Application no: 18/01246/F-3

Location: Warehouse Car Park And Land At Jacobs Douwe Edberts, Ruscote Avenue, Banbury.

This is a revised response following submission of a Transport Assessment and further updates in junction capacity assessment in support of the application.

Transport Schedule

## Drawings

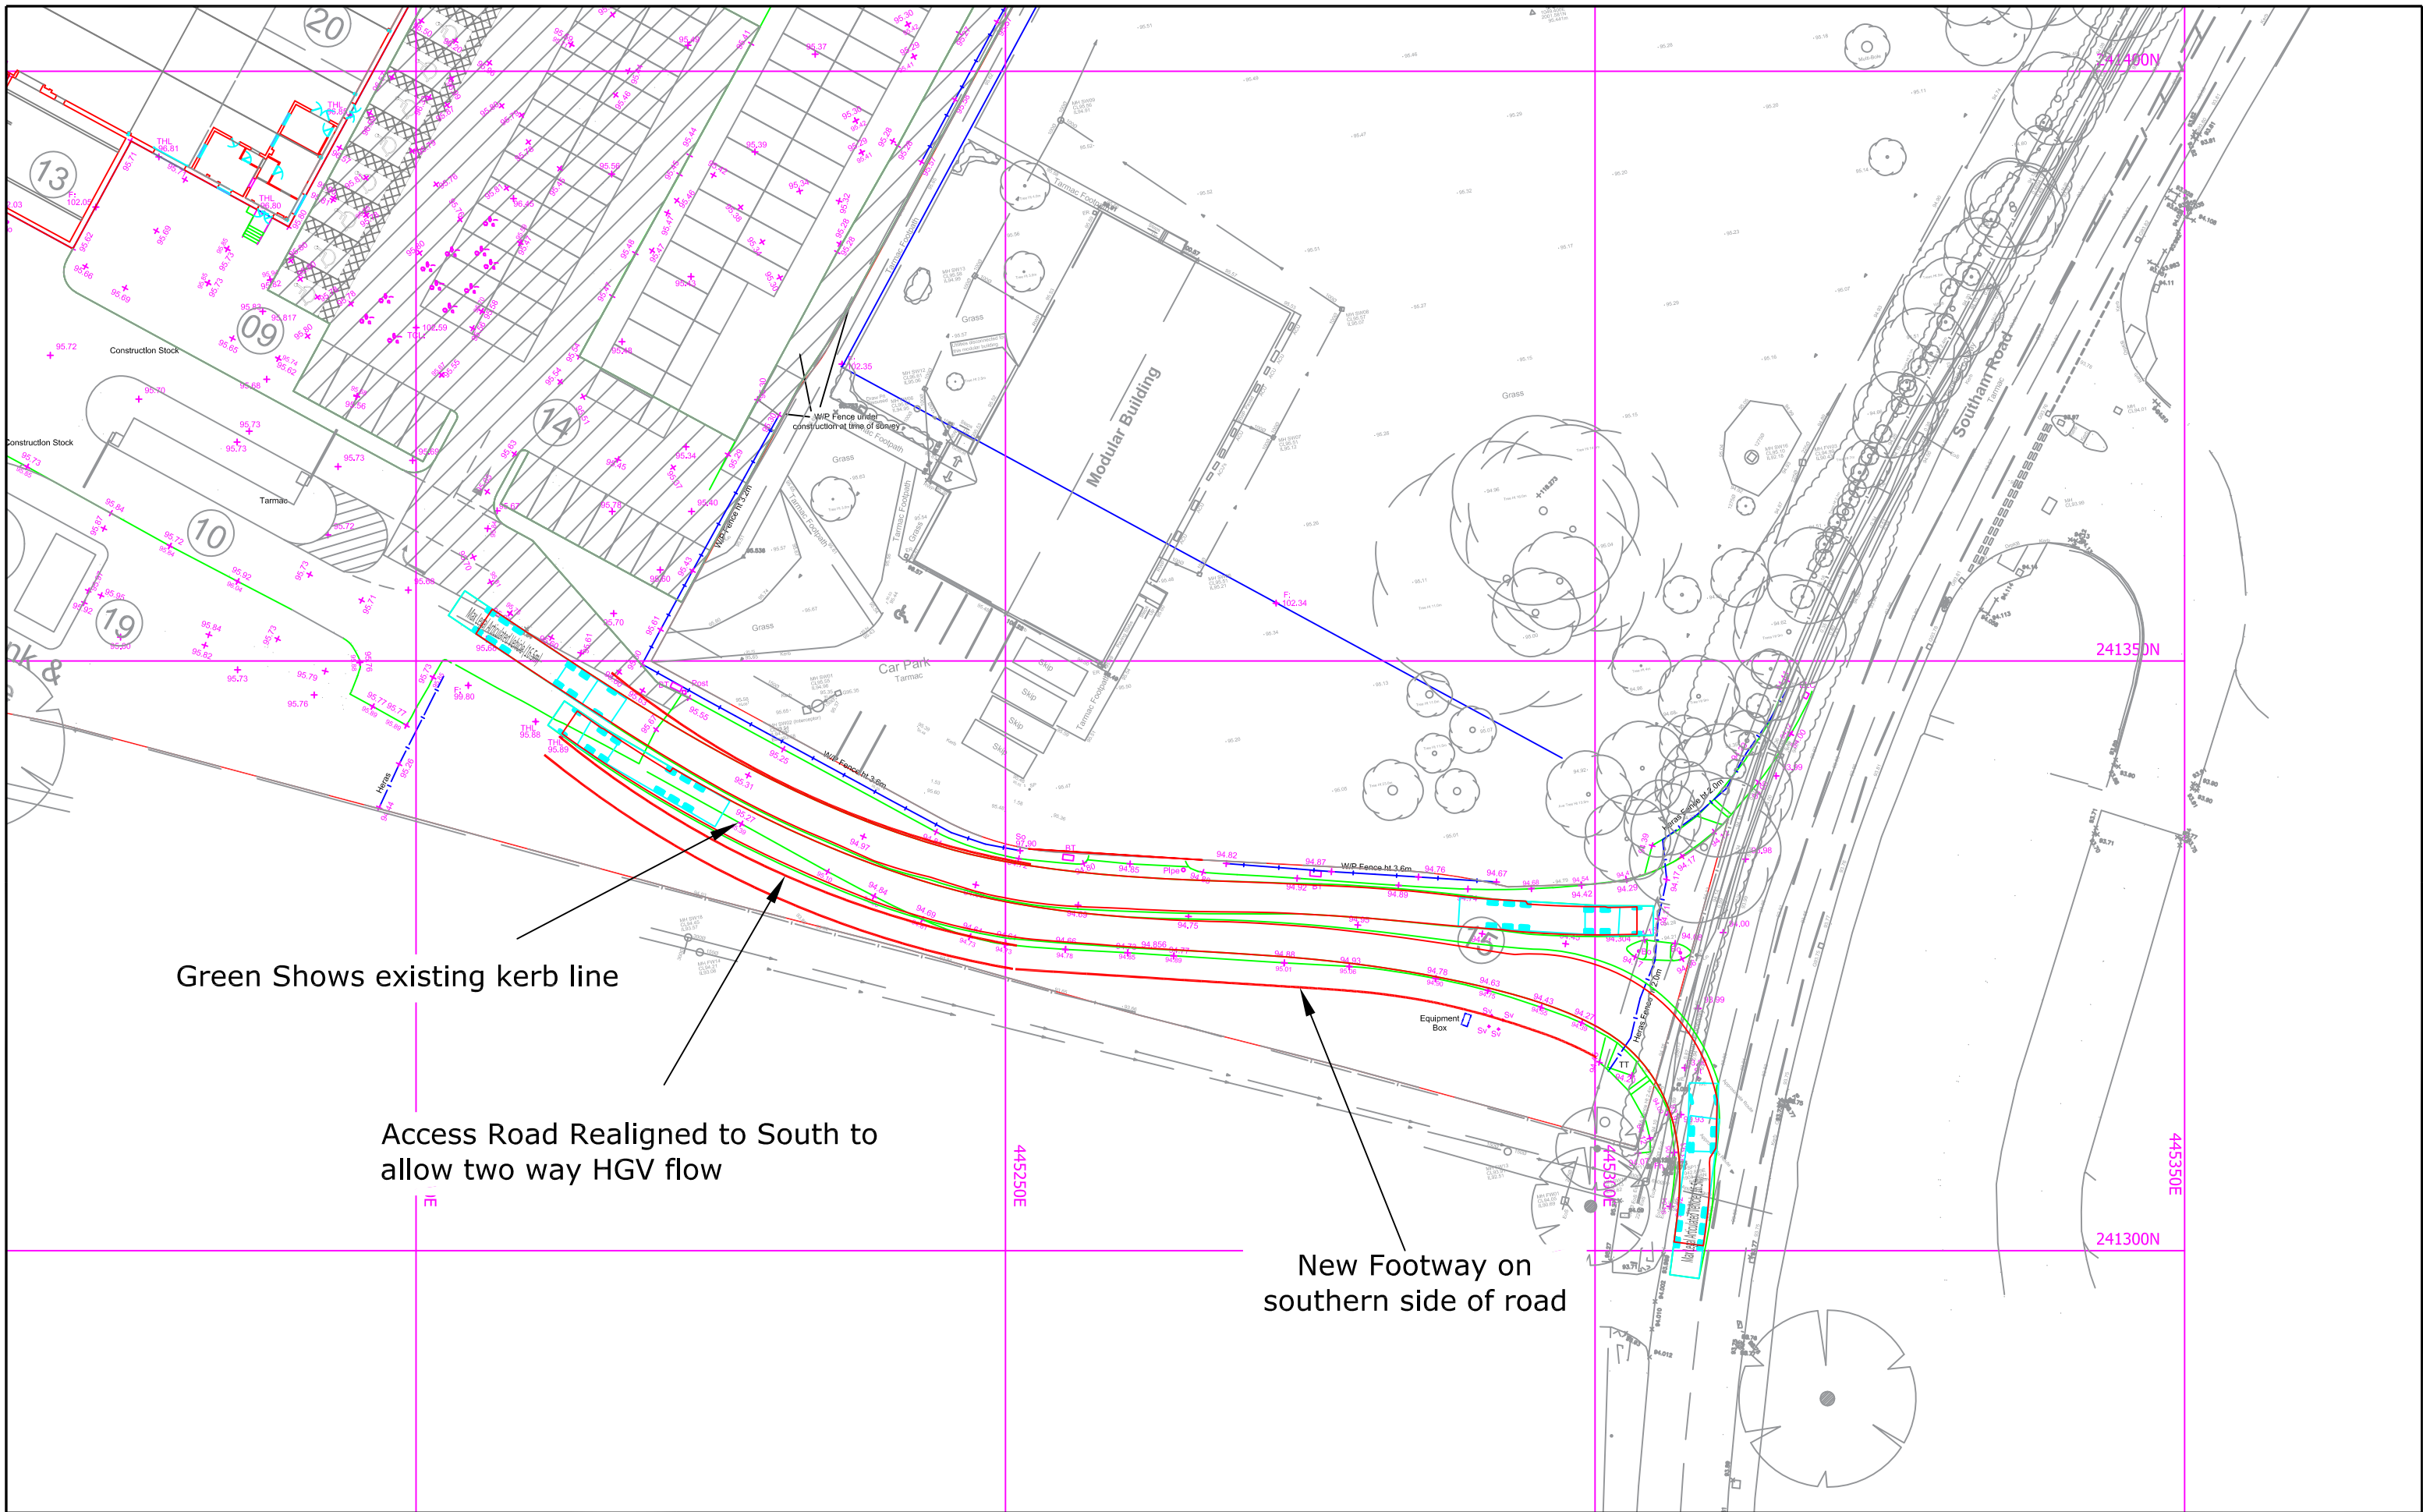
Although the site currently benefits from vehicular access from Ruscote Avenue, the application seeks to acquire new access off Southam Road utilising the recently constructed service access for Waitrose. This would render intensification of use on this service access. Swept path analysis for a 16.5m articulated vehicle has been submitted (Drwg No. 19519 – 03). This is acceptable which shows that the access is suitable for large vehicles.

Site Plan (Location of Proposed Cycle and Smoking Shelter)

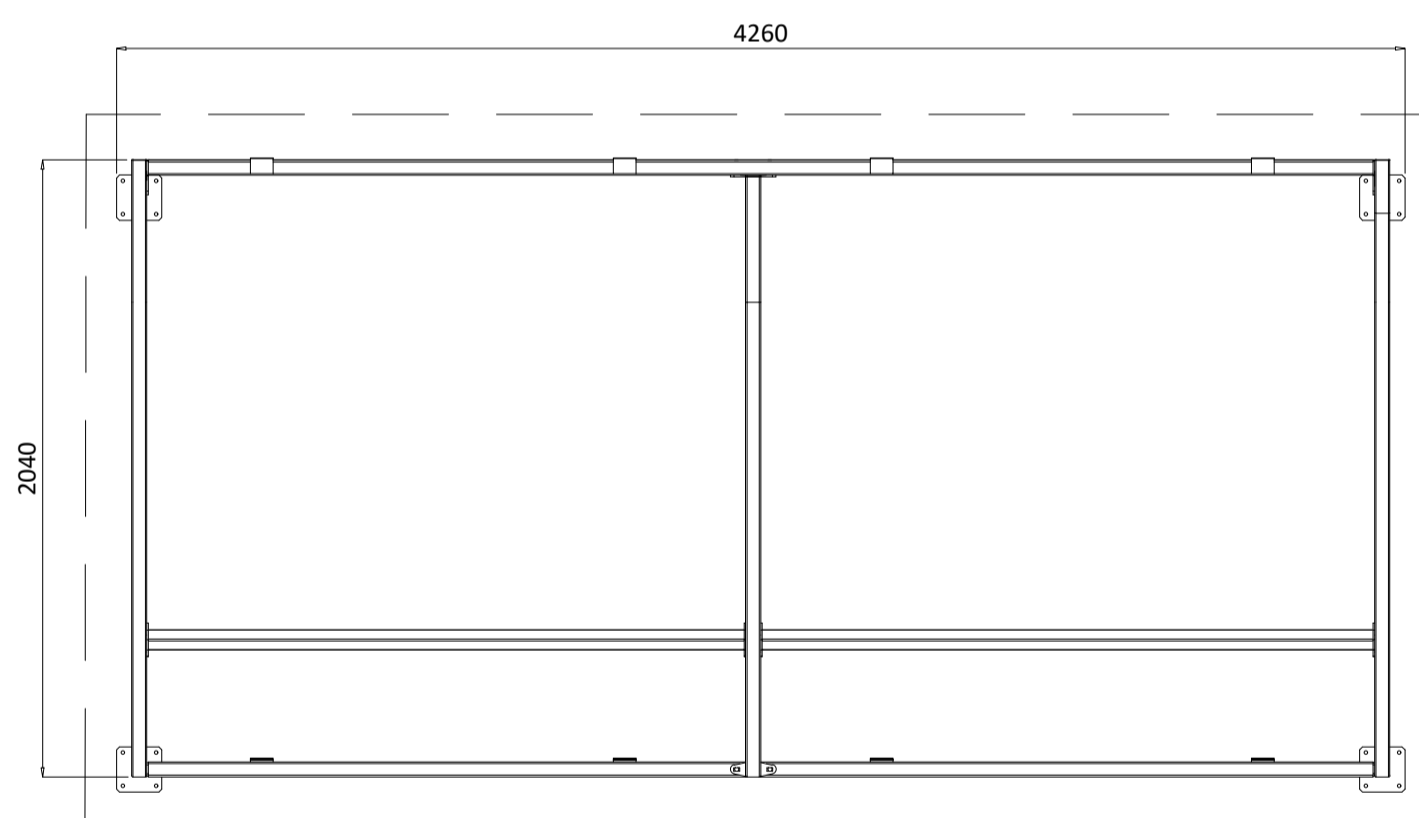
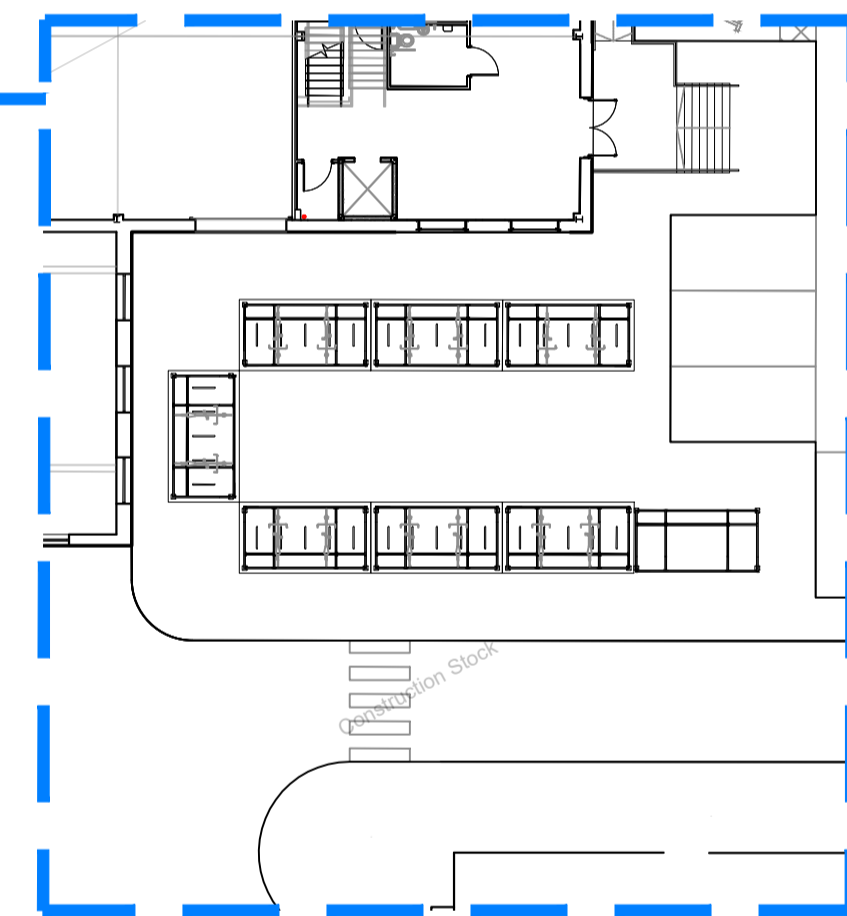
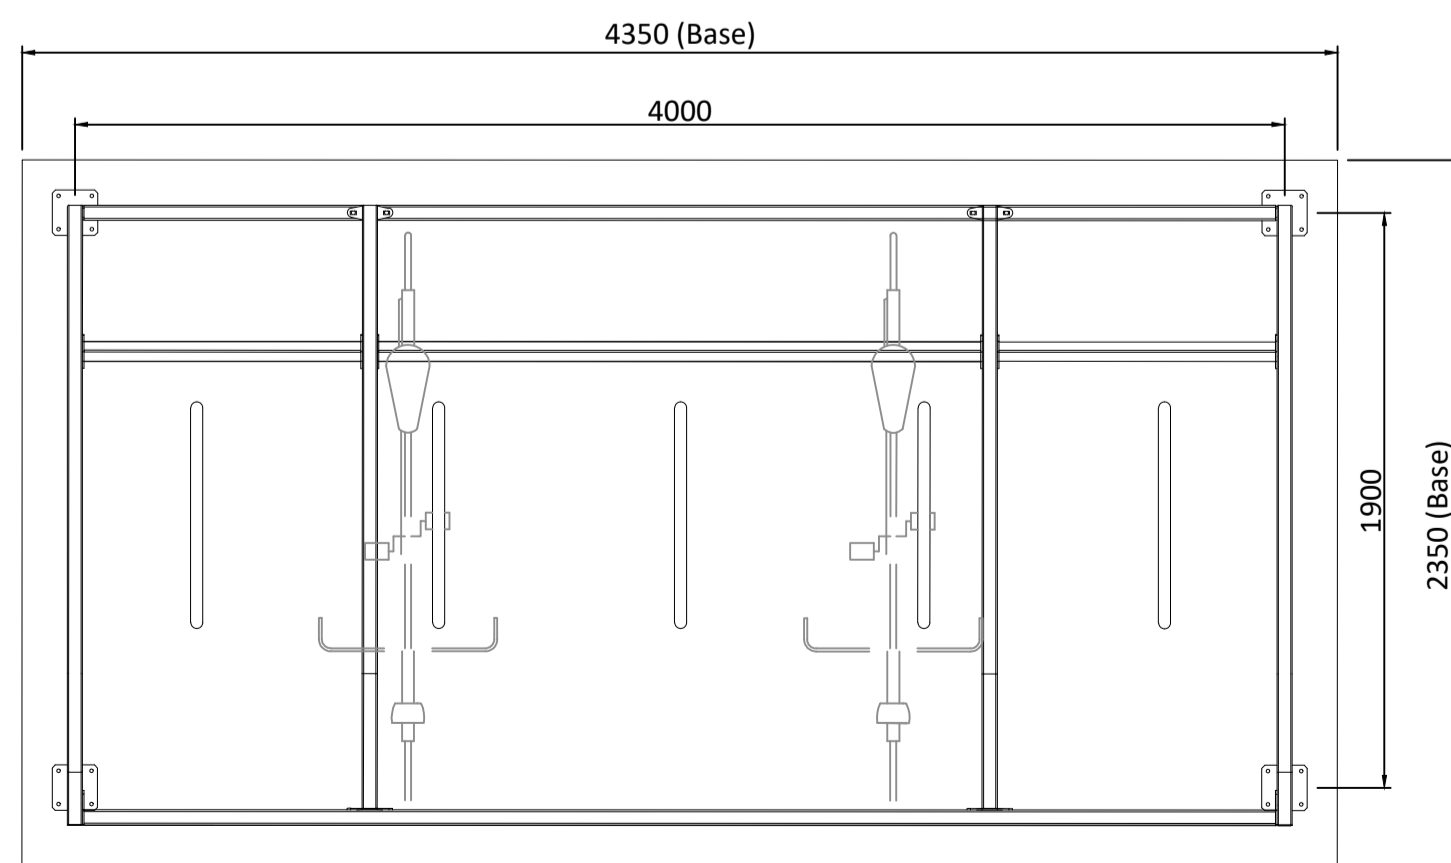
Cycle Parking – The recent site plan has also clarified the application's position on cycle parking provision. Site plan (**Drwg No. 16083 SK007 Rev B**) now shows an acceptable level of cycle provision. It is not clear though of the exact details and whether these are covered or not. I would however wish to suggest that the standalone 15 stands located to south-eastern pocket of the site (towards the access) should be supplemented with a pedestrian crossing facility towards the building.
